KITTITAS COUNTY COMMUNITY DEVELOPMENT SERVICES

12/2/2008

Kittitas County Community Development Services has determined that the Corbett Short Plat (SP-08-00034) is a complete application and hereby grants ***conditional preliminary approval*** subject to the following conditions:

CORBETT SHORT PLAT

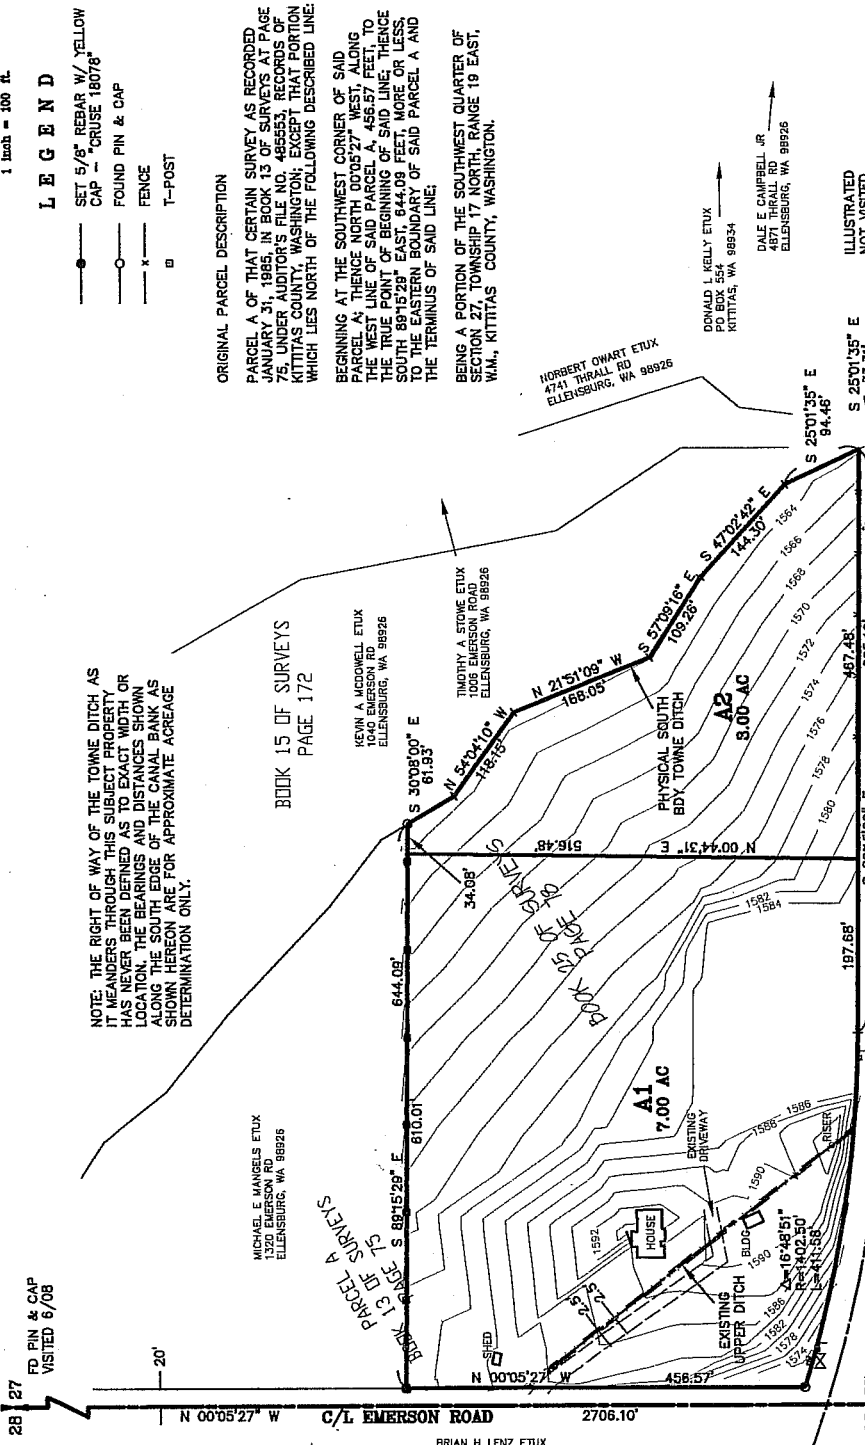
1. Both sheets of the final mylars shall reflect short plat number SP-08-00034 and an accurate legal description shall be shown on the face of the final plat.

10. Lot A1 Access: Access to Lot A1 shall be from the existing access on Emerson Road. There appears to be a secondary access onto Thrall Road on the lower part of the lot. This shall not be used as an access to the property for any reason without first being permitted by the Department of Public Works.
11. Lot A2 Access: Access to Lot A2 shall be from the location stated in Road Variance 08-35 which was approved on November 20, 2008. The access shall be constructed as a single-use driveway.
